MORGAN AND MORECAMBE OFFSHORE WIND FARMS: TRANSMISSION ASSETS

Response to Section 51 advice

December 2024

Document reference: S_S51_1

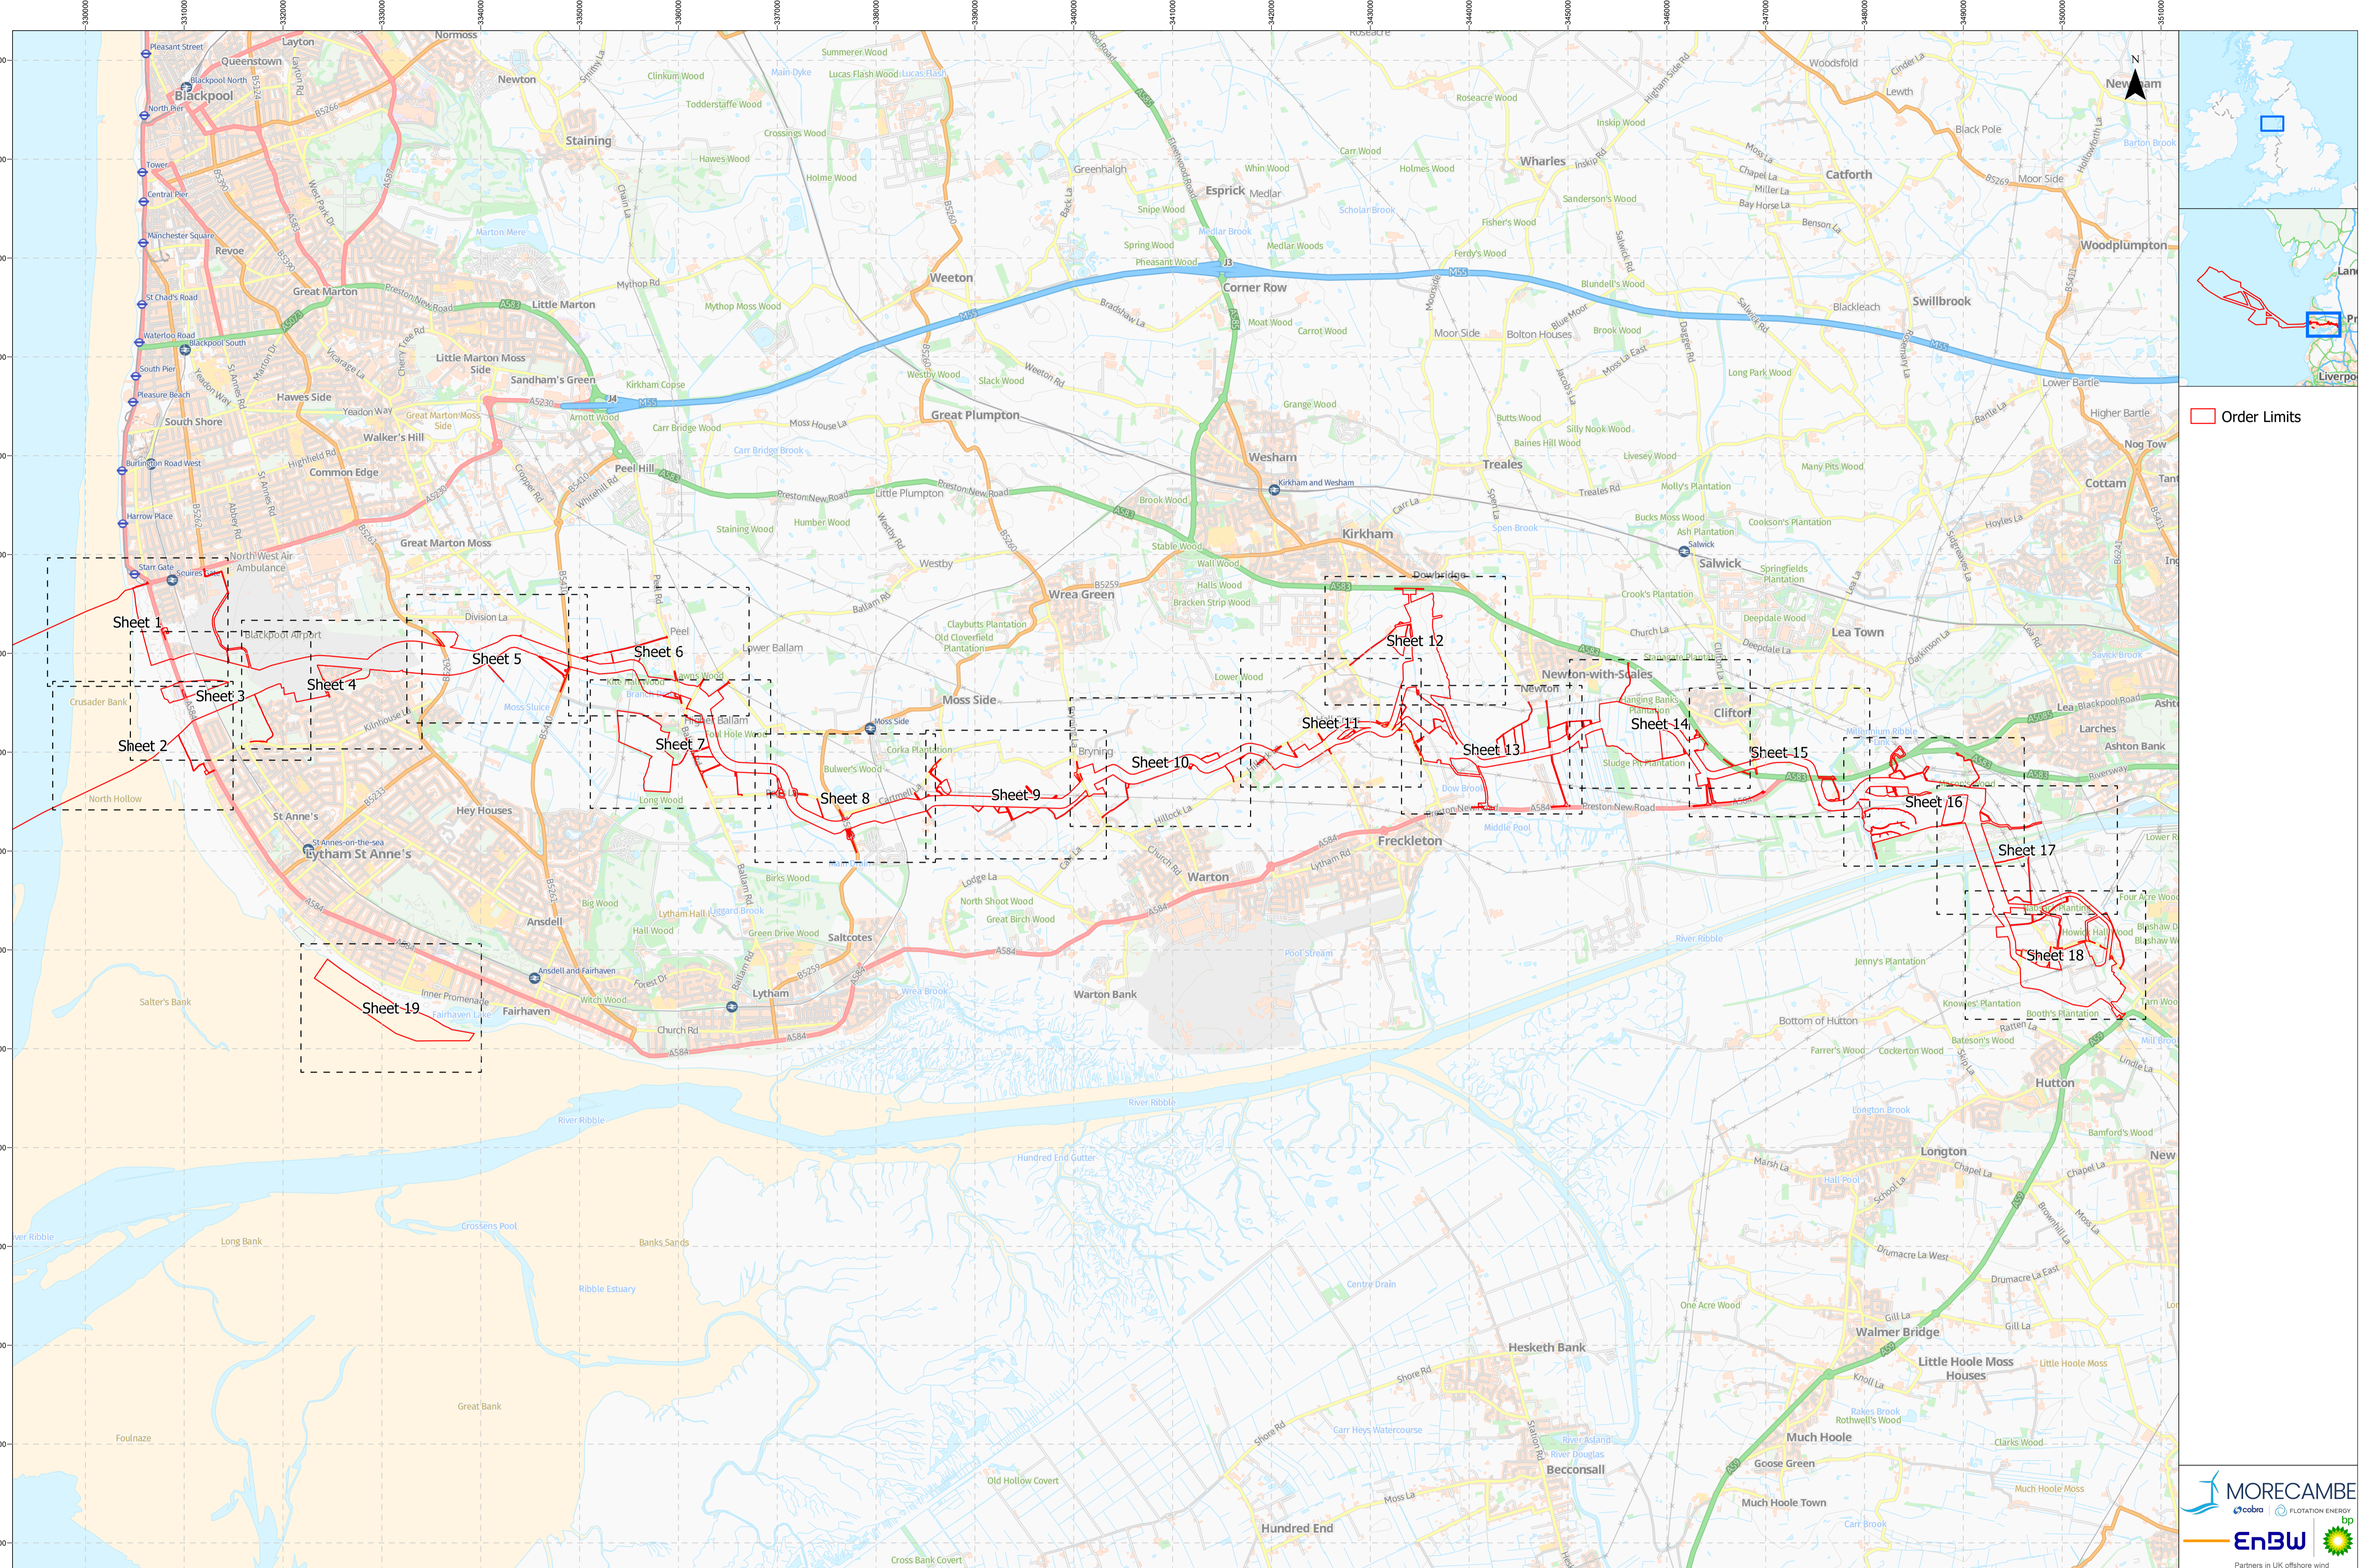
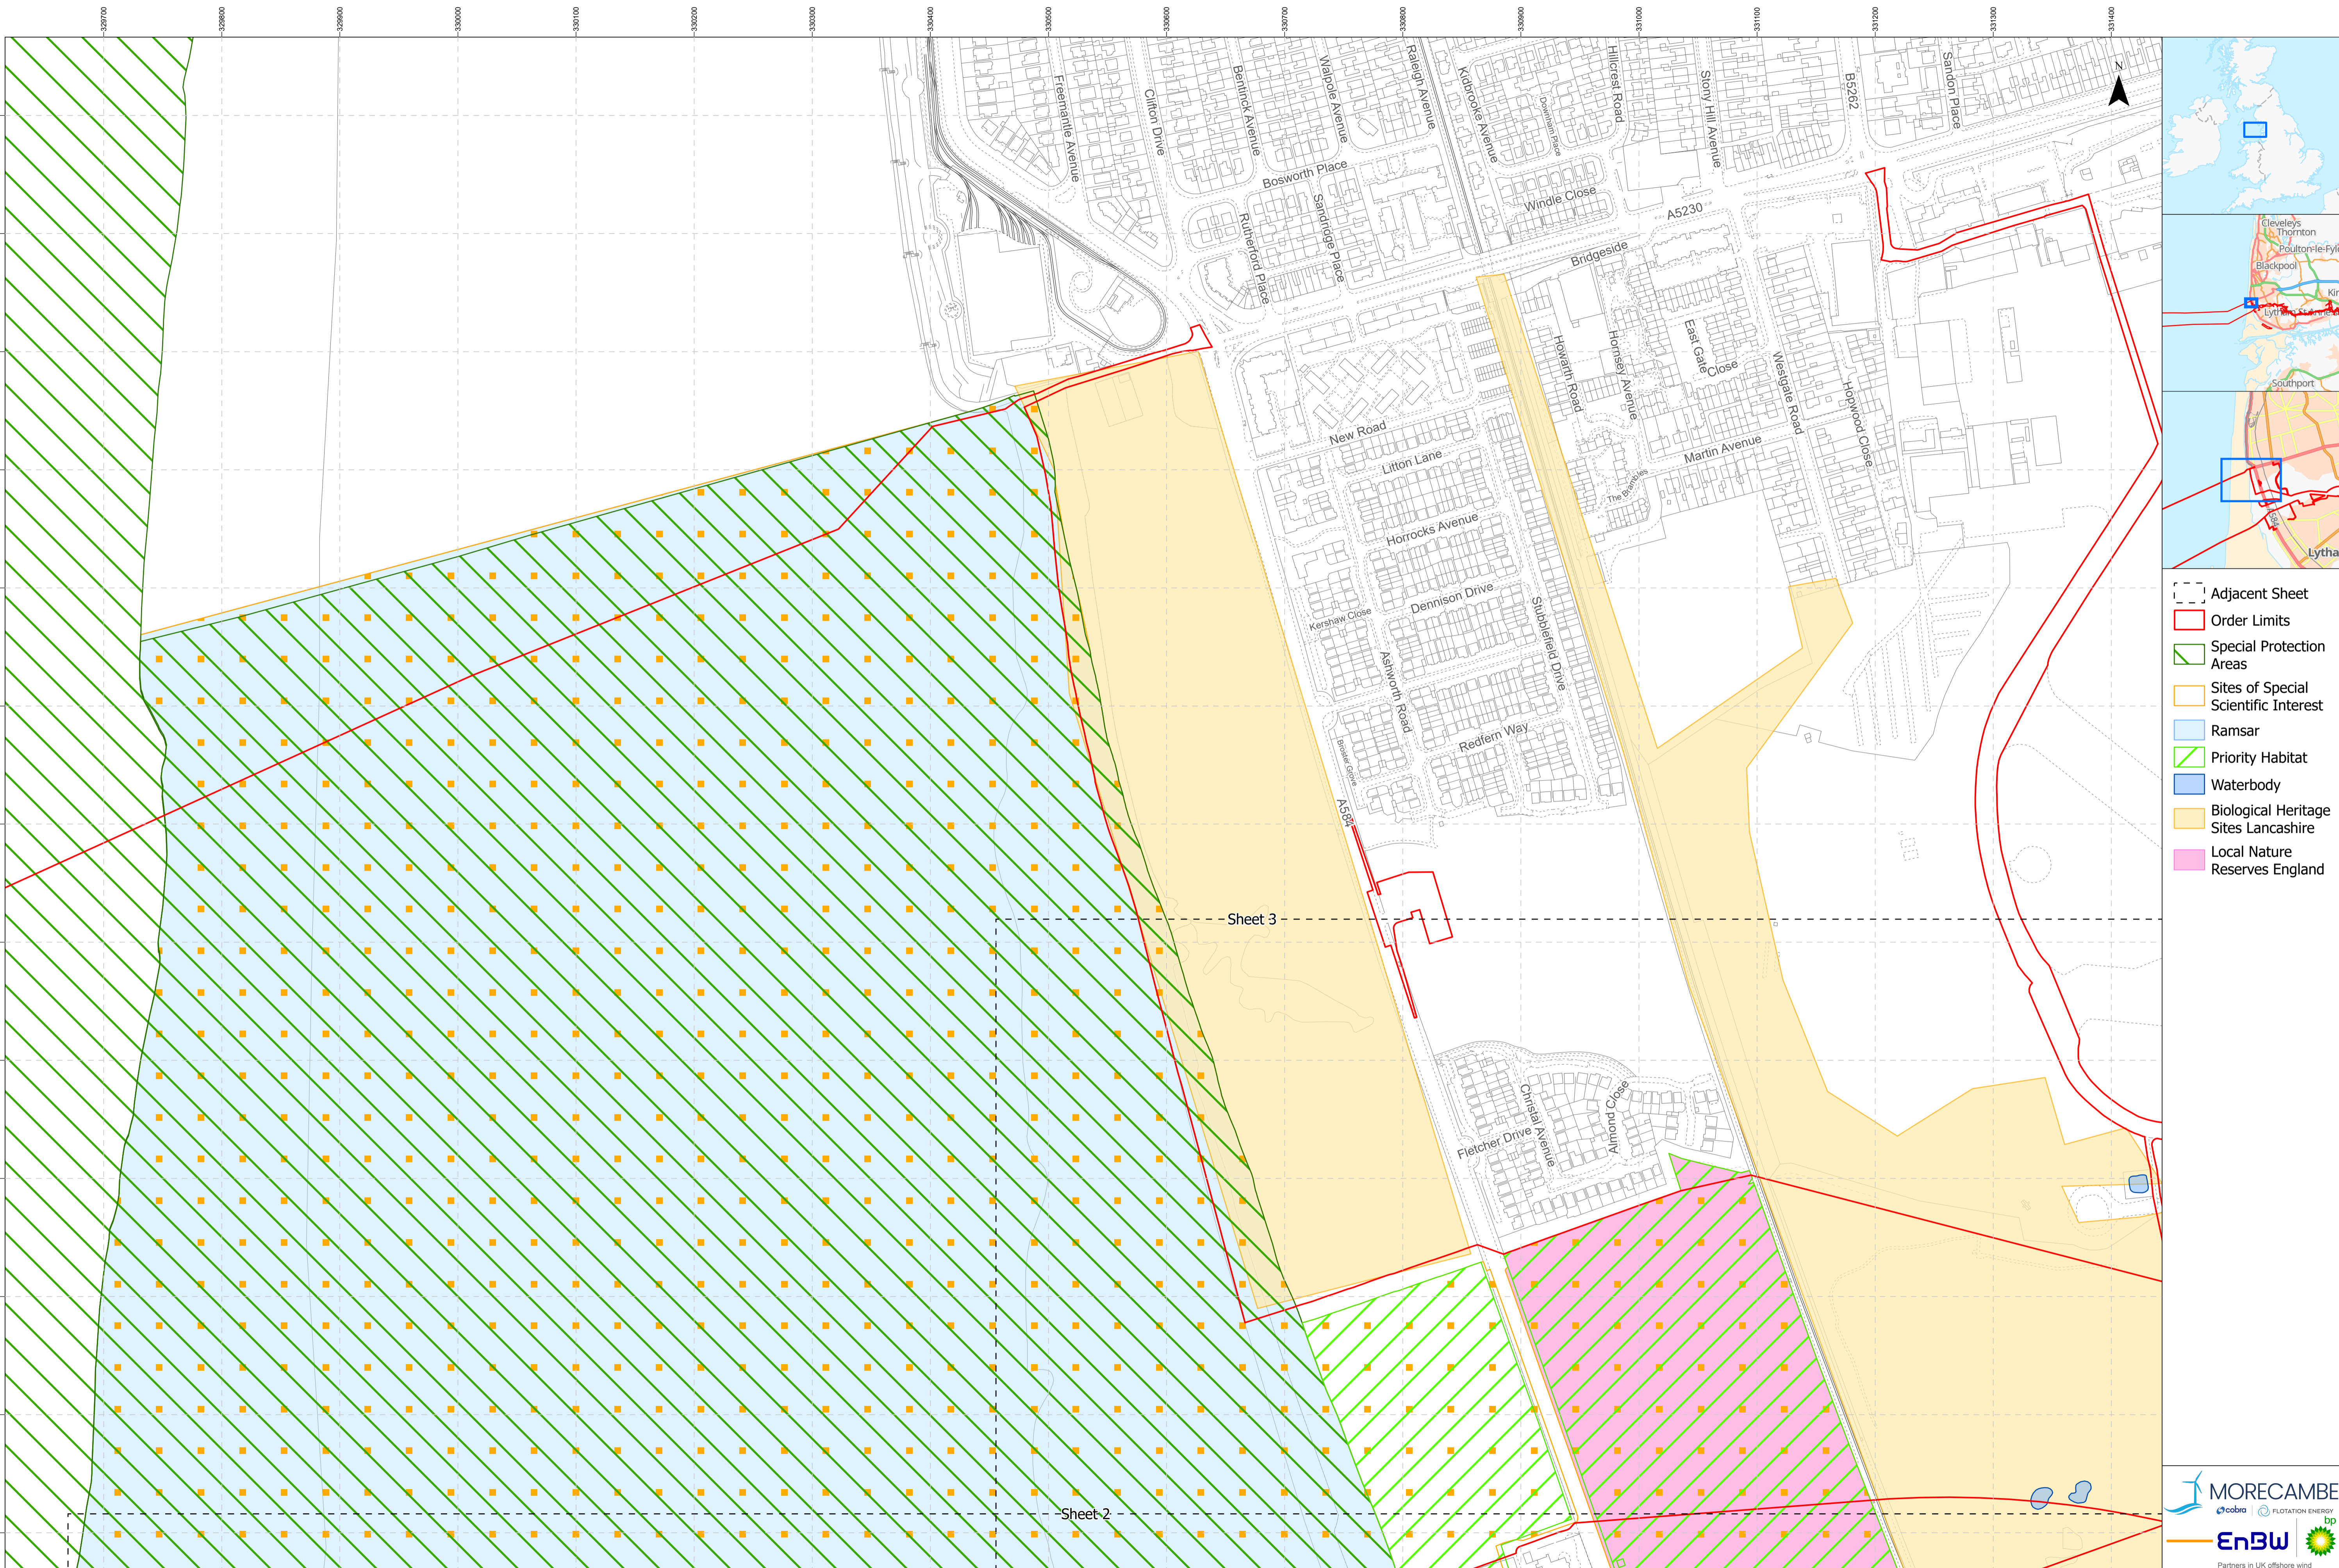
Onshore Statutory and Non-Statutory Nature Sites and Onshore Historic or Scheduled Monument Sites	<p>“The plans showing Onshore Statutory and Non-Statutory Nature Sites (and Waterbodies in a River Basin Management Plan) (Doc B14) and Onshore Historic or Scheduled Monument Sites (Doc B16) present the sites, rivers or historic assets, however these are not labelled (unlike the equivalent offshore plans). The Applicants are advised to provide an updated set of figures with appropriate labelling of the features being represented. “</p>	<p>The Applicants have updated this document with the requested changes and have submitted it to the Planning Inspectorate (document reference: B14/F02 and B16/F02). Both documents contain a Schedule of Changes.</p>
Onshore Historic or Scheduled Monument Sites	<p>Between the onshore historic or scheduled monument sites (Doc B16) and ES Volume 3 (Doc F3.12, figures for chapter 5), there appear to be some minor differences in terms of the specific assets recorded between these drawings. An example is Doc F3.12 ES figure 5.7 compared to sheet 3 of Doc B16. The Applicants are advised to provide an updated set of figures which are consistent in the features being represented, with appropriate labelling.</p>	<p>The Applicants have reviewed the Onshore Historic or Scheduled Monument Sites plan alongside the Environmental Statement (ES) Volume 3 Figures and can confirm that the data included is the same. However, the data shown on the ES figures has been separated based on the time period for the records. To facilitate ease of cross-referencing between the documents, labels referencing the heritage asset list entry have been added to the Onshore Historic or Scheduled Monument Sites plan (document reference: B16/F02). The Applicants have submitted the updated Onshore Historic or Scheduled Monument Sites plan (document</p>
